**Yorkshire Water Services**  
**Developer Services**  
**Sewerage Technical Team**  
**PO BOX 52**  
**Bradford**  
**BD3 7AY**

**Your Ref: 2023/91212**  
**Our Ref: Z002464**

**1st June 2023**

**Land off Bankfield Drive, Holmebridge, Holmfirth, HD9 2PH - Erection of 16 dwellings with access from Laithe Avenue**

JOB No	DRG No	REV
21043	101	F

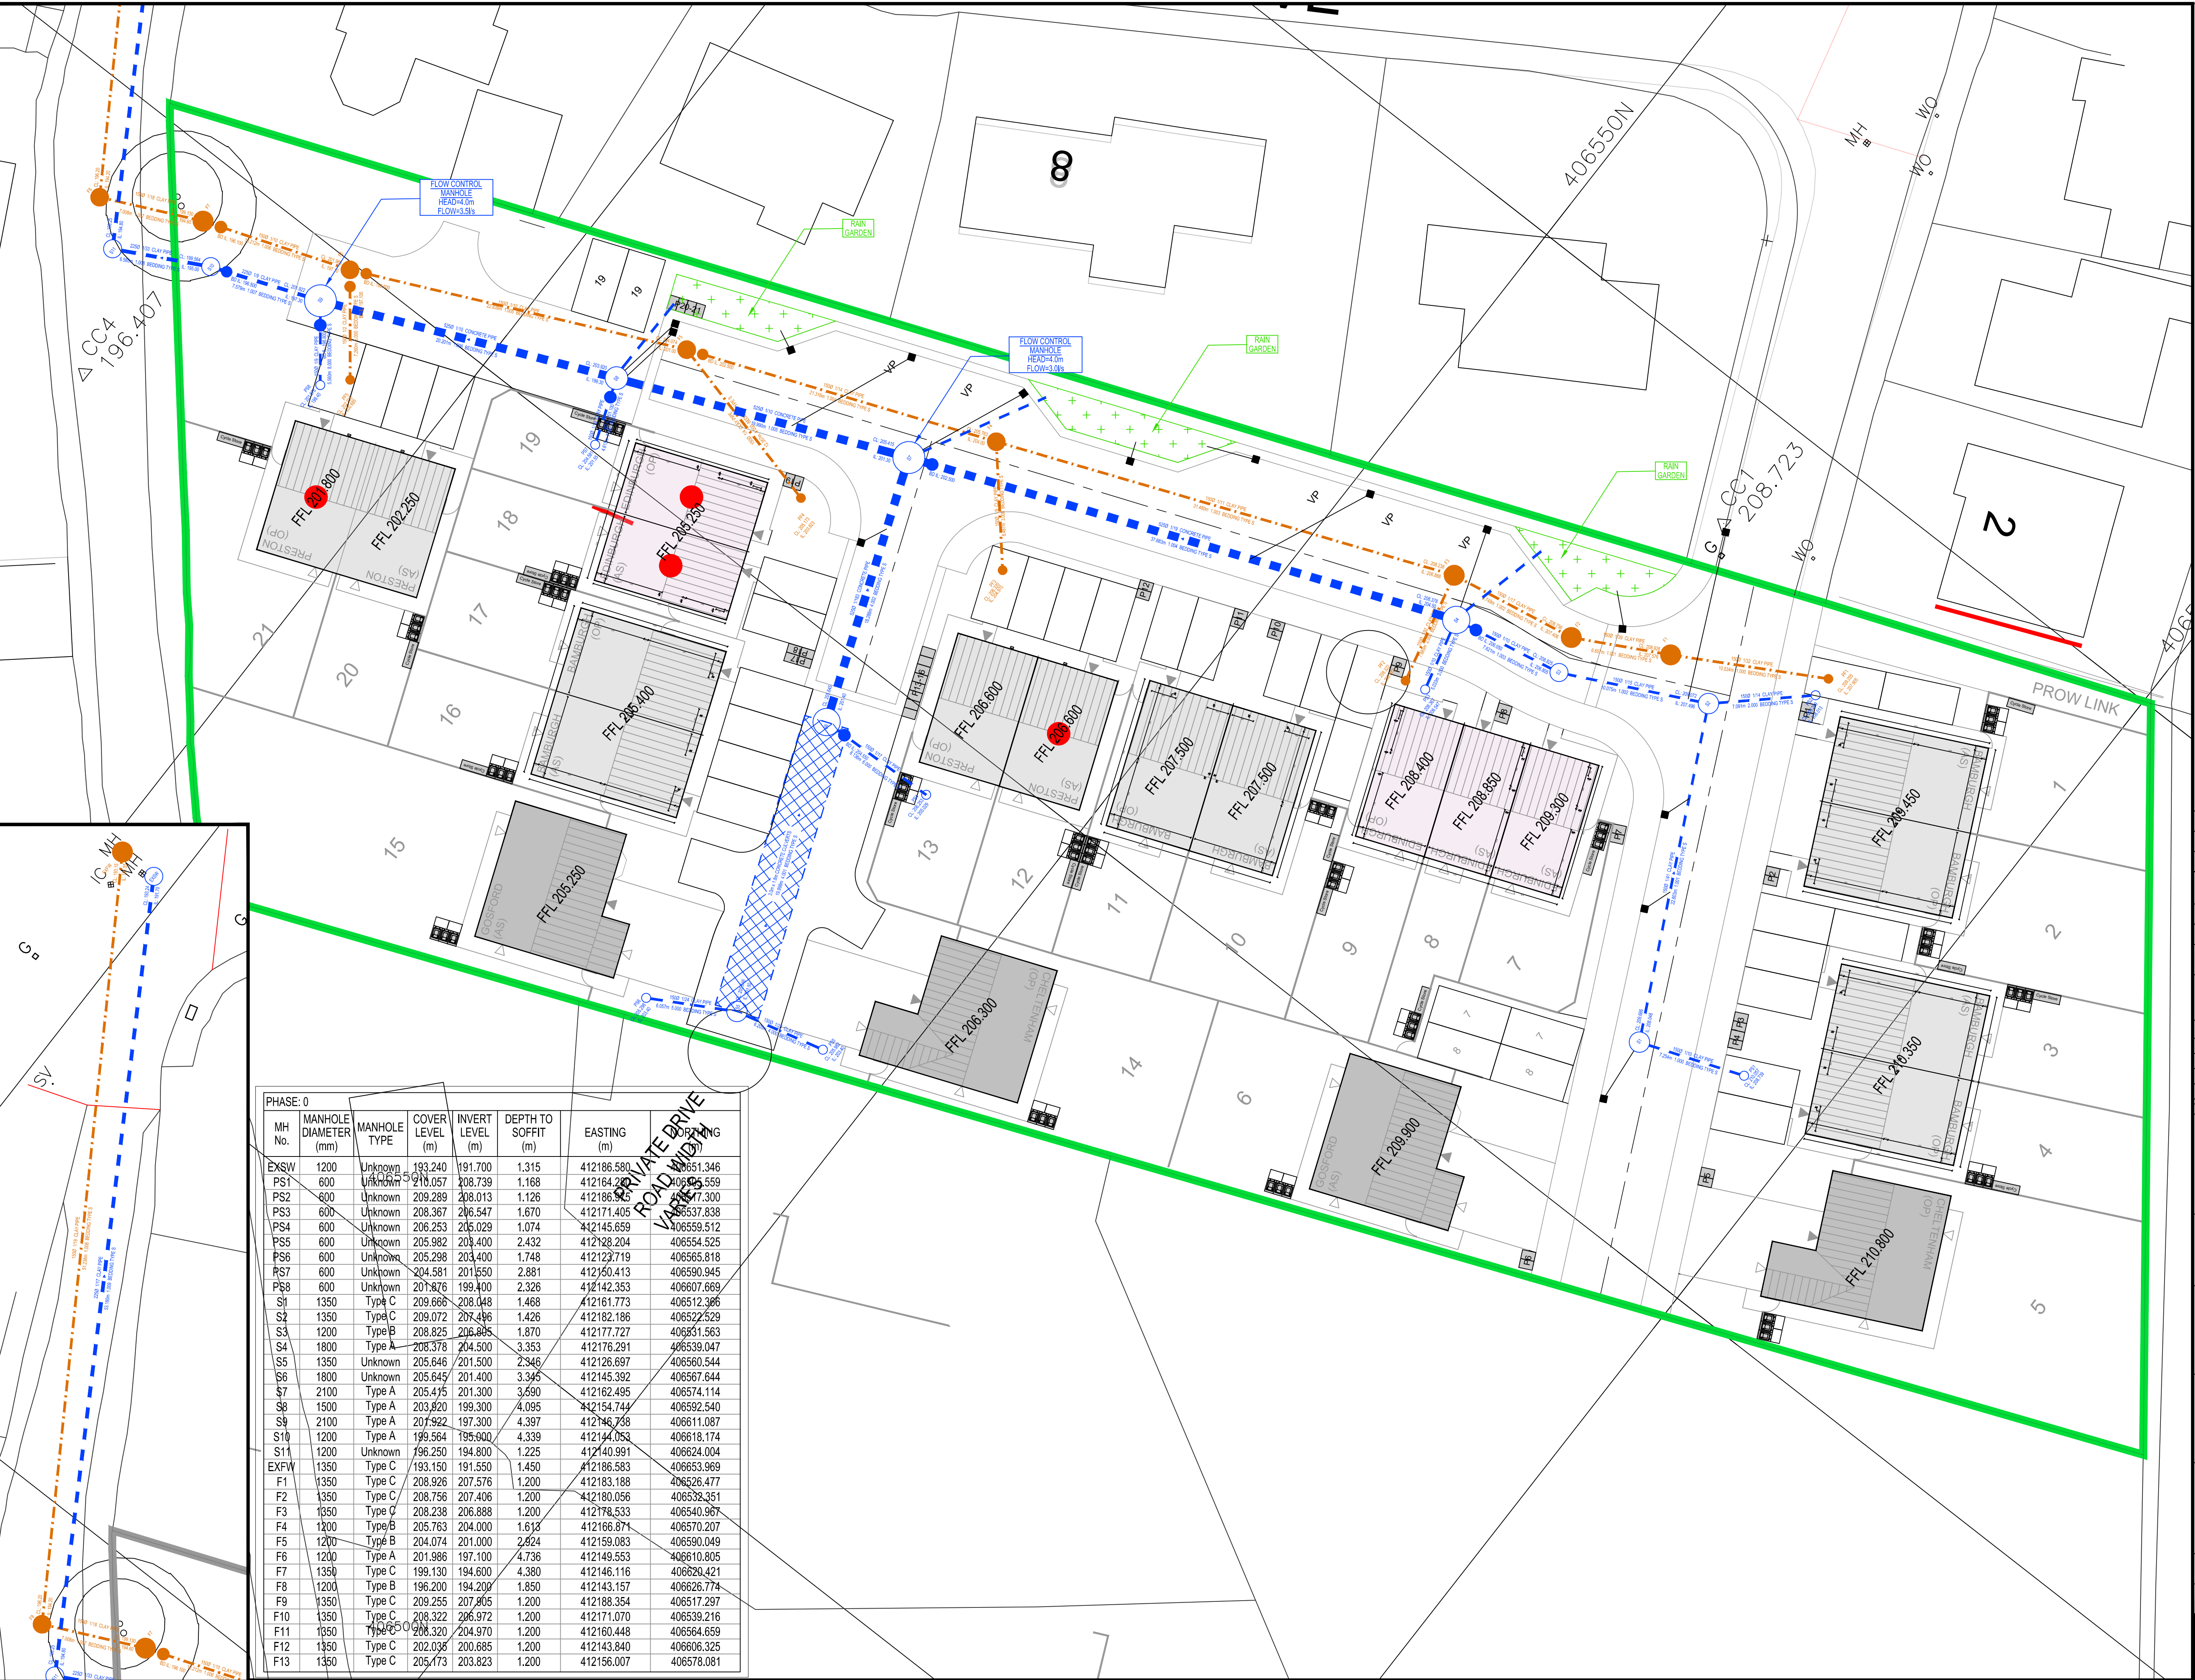
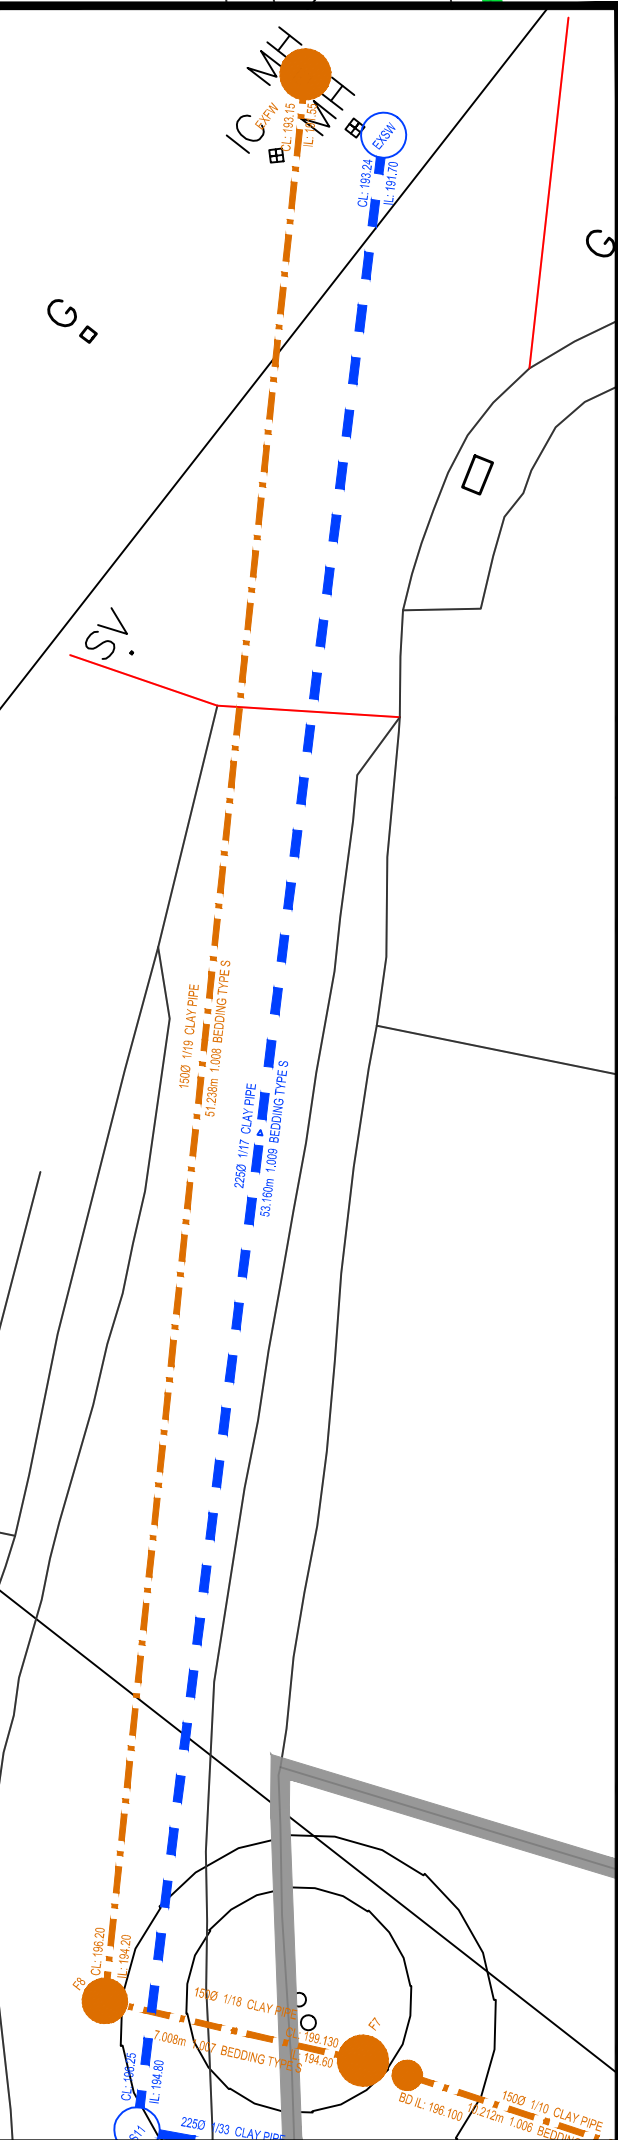
1.) The drainage details submitted on drawing 21043 101 (revision C) dated 28/03/2023 that has been prepared by Advant Engineers require amendments, but if planning permission is granted, the matter can be dealt with via condition. The following points should be addressed:

- a.) evidence should be submitted to show that other (than discharge to public sewer) means of surface water disposal have been considered and why they have been discounted
- b.) evidence of existing impermeable areas positively draining to the public sewer is required to prove rate of discharge of 8.8 litres/second.
